Application for a Non-Material Amendment Following a Grant of Planning Permission

Demolition of single storey rear extension; Proposed single storey rear extension; new rear facing attic dormer window to replace roof window (revised scheme)

23/00539/HOU and 23/00540/LBC

Omission of glazing bars from the new dormer window and from the replacement first floor window;
Change design of rear ground floor extension doors;
Raise dining area floor by 300mm.

Drawing Title		
PROPOSED FLOOR PLANS		
Scale	Date	Drawn
1:100 @ A3	Sept 2022	rmm
Project No.	Drawing No.	Revision
22022	104	B

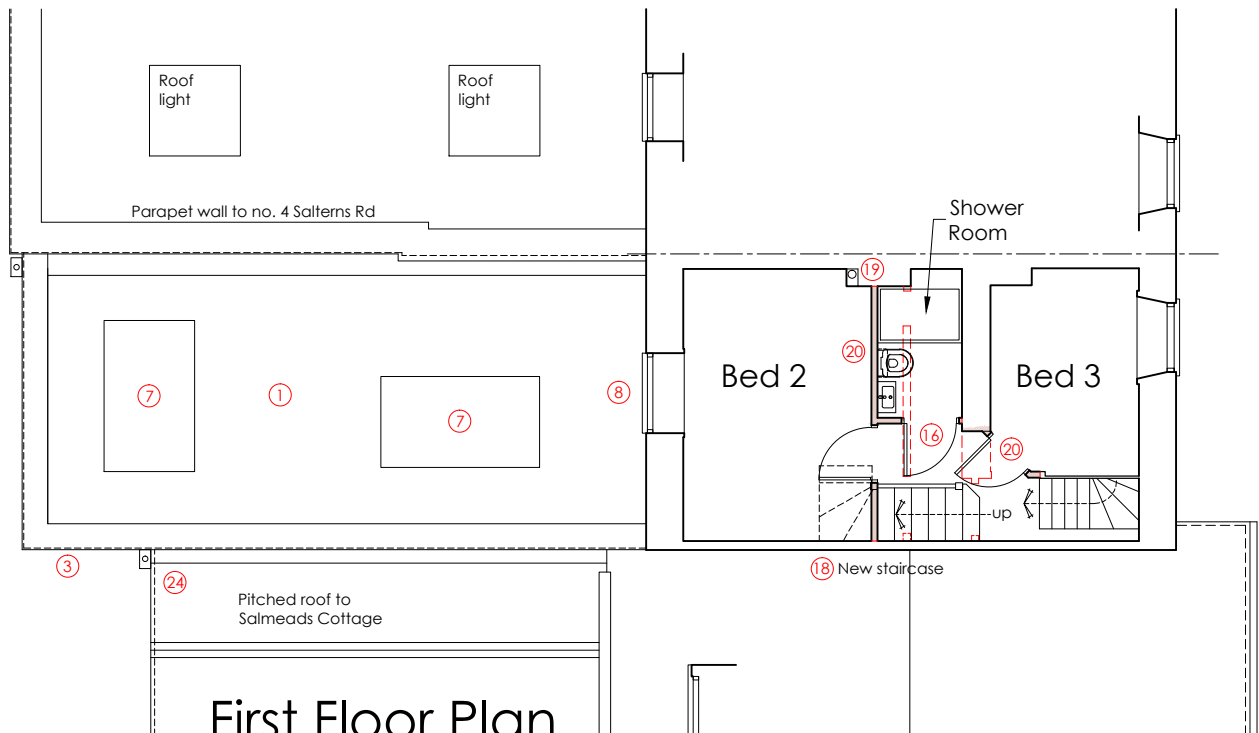
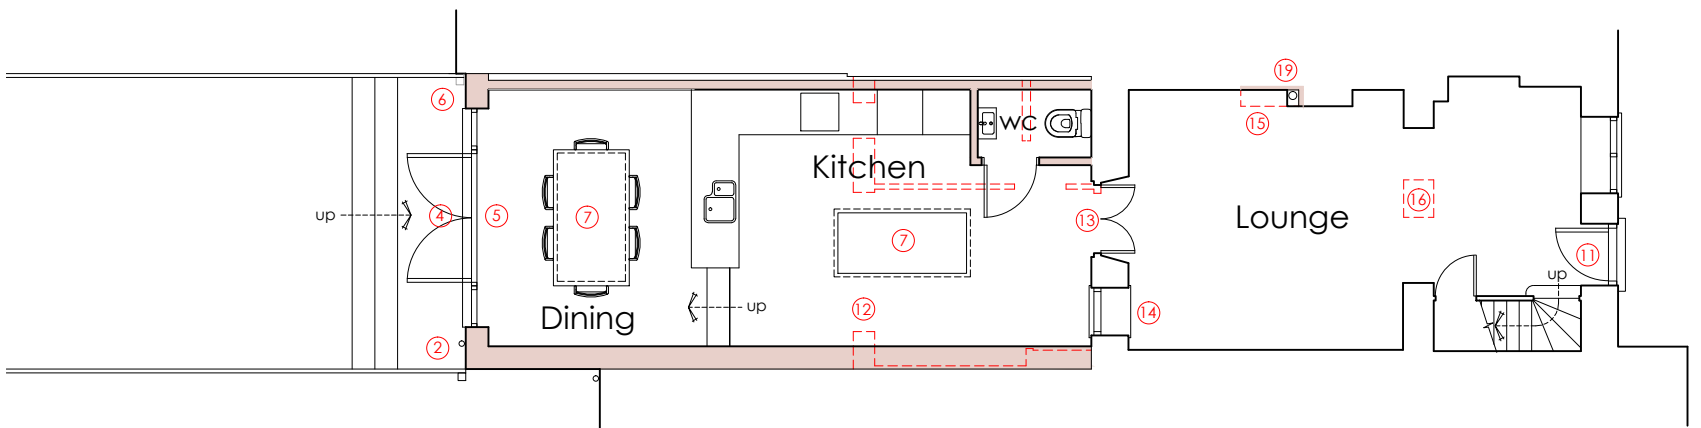
The applicants, also again on reflection, would prefer to see a conventionally hinged pair of doors leading out into the garden instead of a set of bi-fold doors. These are now proposed to be in PVC-u.

The last change is to offer an additional safeguard to flooding by raising the dining area floor level by a nominal 300mm. This will match the level of the neighbouring Sweetpea Cottage rear extension although the new parapet wall height will remain as currently consented.

104A Proposed Floor Plans
105A Proposed Elevations and Section

104B Proposed Floor Plans
105B Proposed Elevations and Section

Drawing Title **PROPOSED ELEVATIONS & SECTION**

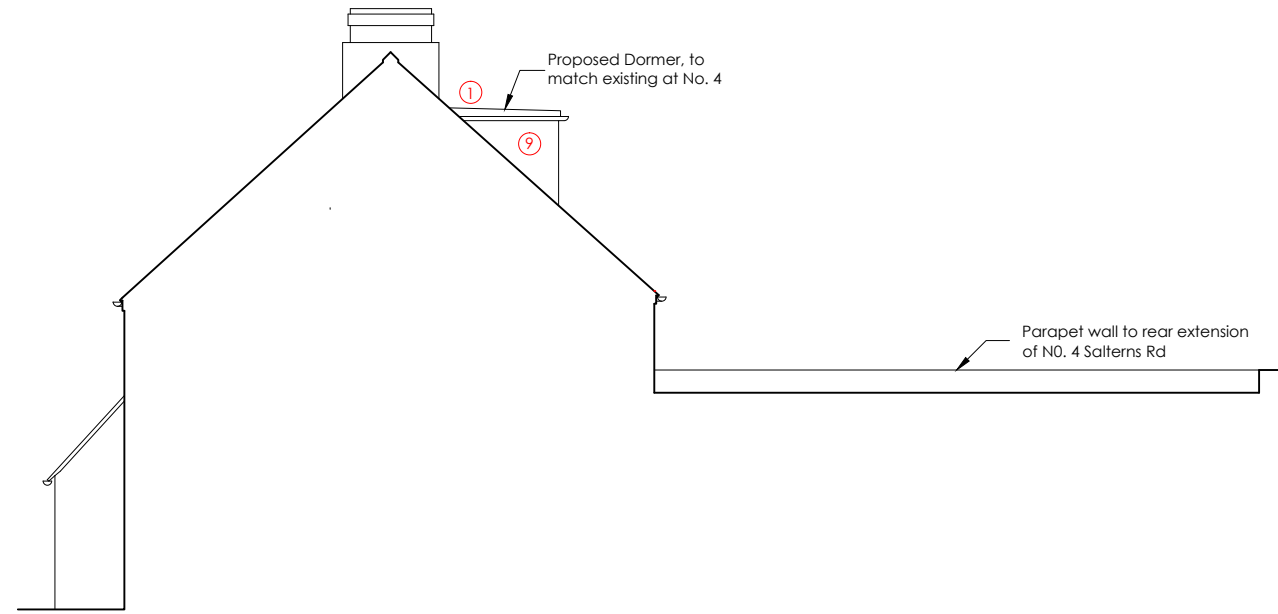
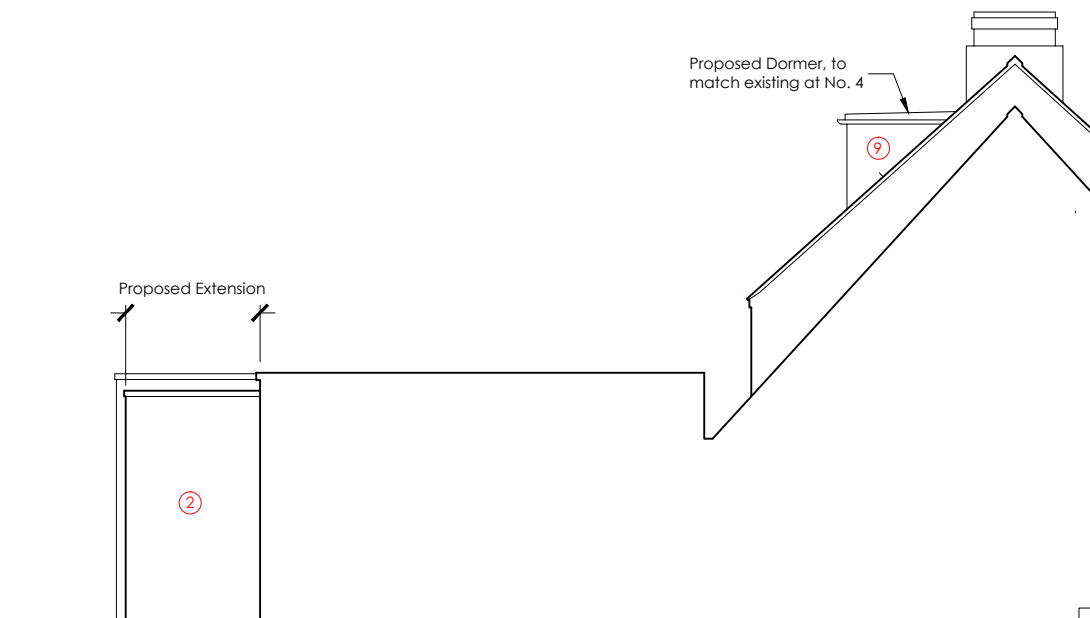
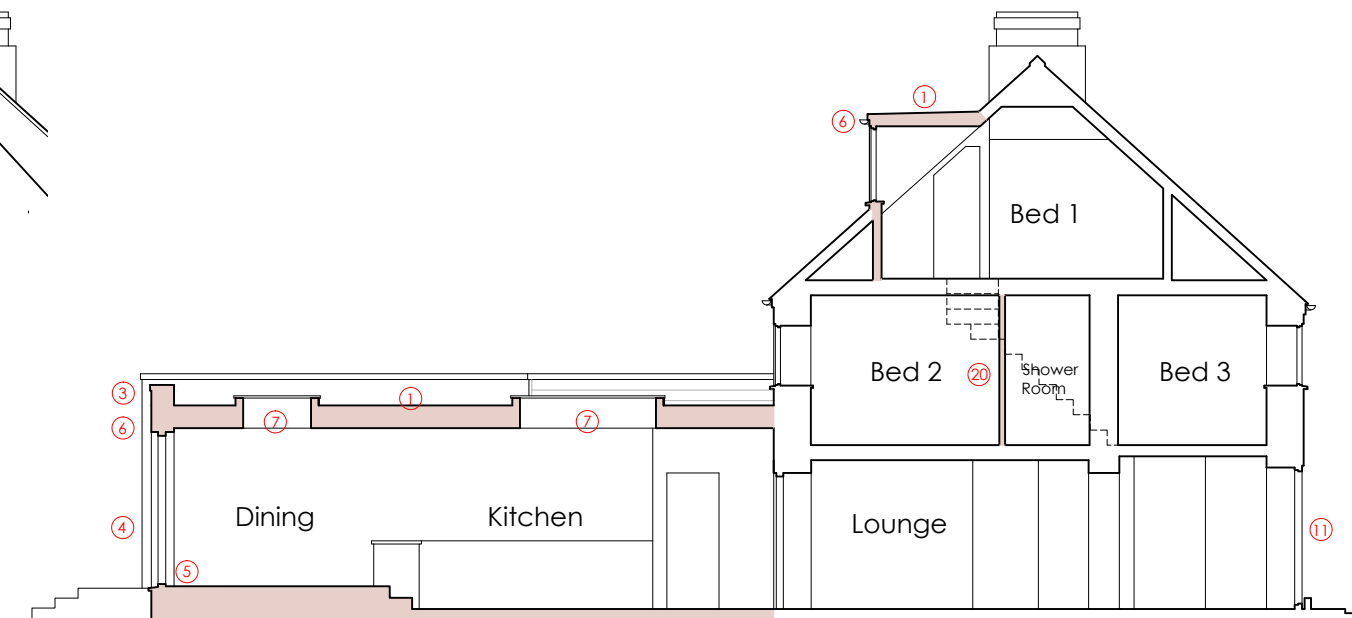
The applicants, on reflection, would wish to see the rear windows match the existing front ones. This would see the glazing bars omitted to leave single glazing panels in each window.
